A-1 CHIPSEAL GRADING AND EROSION CONTROL PLAN GRADING PLAN JULY 2022

A-1 CHIPSEAL
GRADING AND EROSION CONTROL PLAN
GRADING PLAN

A-1 CHIPSEAL
GRADING AND EROSION CONTROL PLAN
EROSION CONTROL PLAN

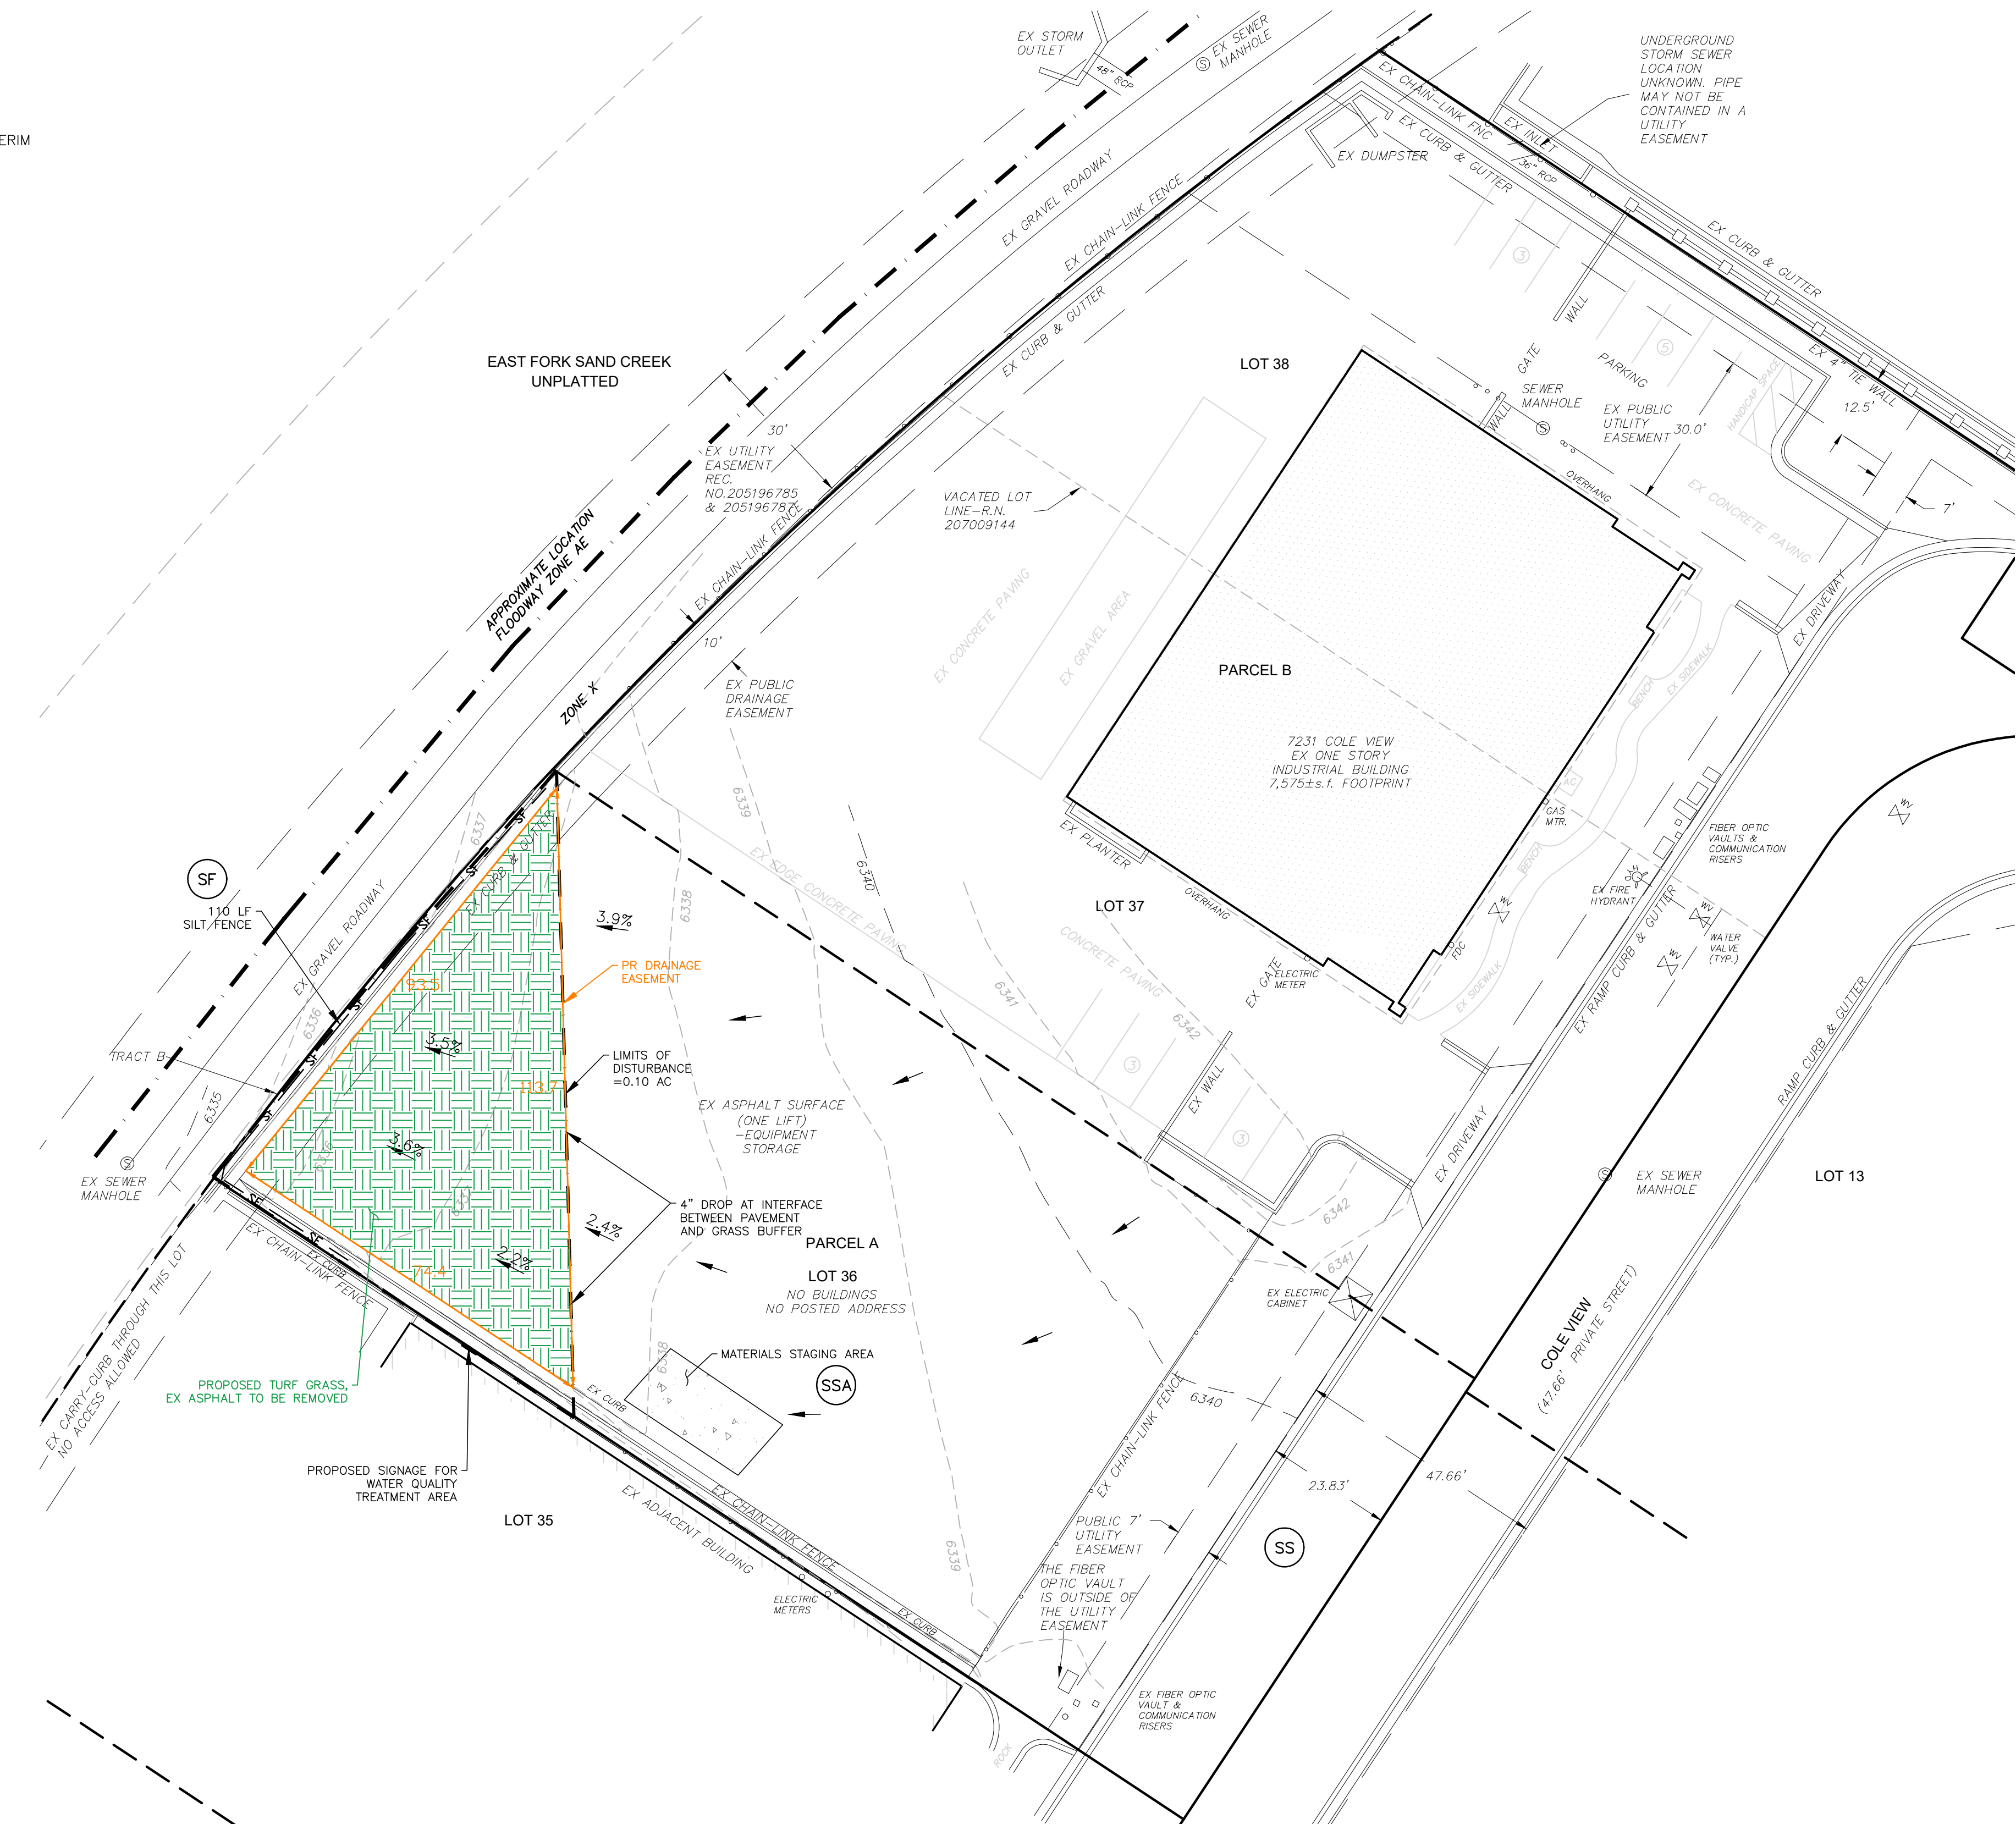
- All RPA/SPA areas will need to be within a no build/drainage easement (or tract). The easement should read: "No impervious improvements shall be constructed within the easement (i.e., patios, hardscape, gravel, raised garden beds, recreational facilities, etc.). Turf grass vegetation with a uniform density of at least 80% is required. In addition, the existing slope must be maintained".

- Show suitability of topsoil of RPA and steps for proper preparation of topsoil per recommendations in MHFD detail T-0 Table RR-3
- Provide a detail for the UIA:RPA interface that shows the recommended vertical drop of 4"

- Show signage to be posted in RPAs so maintenance personnel and owners know that the area is a water quality treatment area (not just a regular grassy area). The signage should say something like: "Water Quality Treatment Area, do not pollute. Area to remain vegetated and properly maintained per the O&M Manual."

- The runoff reduction RPA is considered a WQ Facility and requires a signed Maintenance Agreement

Runoff Reduction Requirement: Irrigation (temp or permanent) is necessary to establish sufficient vegetation and not just weeds.

provide dimensions

Show the slope of the runoff reduction area

Please add a note stating that runoff reduction turf grass requires 80% vegetation in order to close the permit.

A-1 CHIPSEAL
GRADING AND EROSION CONTROL PLAN EROSION CONTROL DETAILS

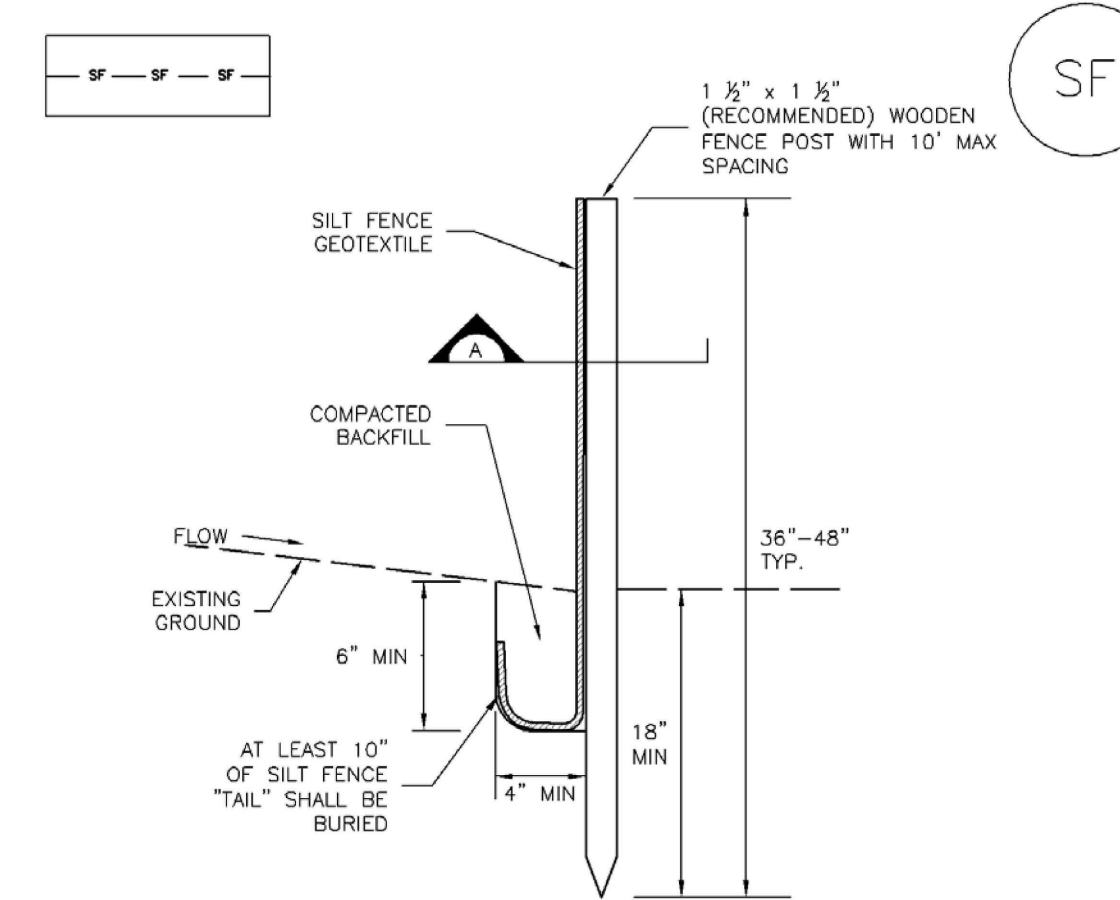
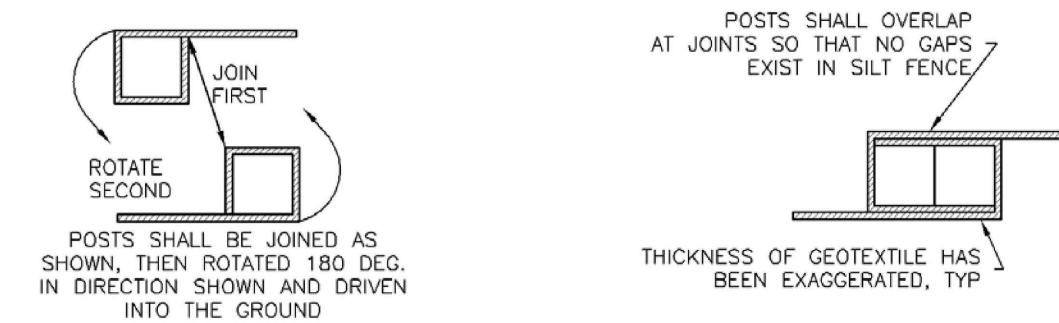
please provide seed mix for turf grass
Note: comment generated during the 3rd review due to the WQ design changes
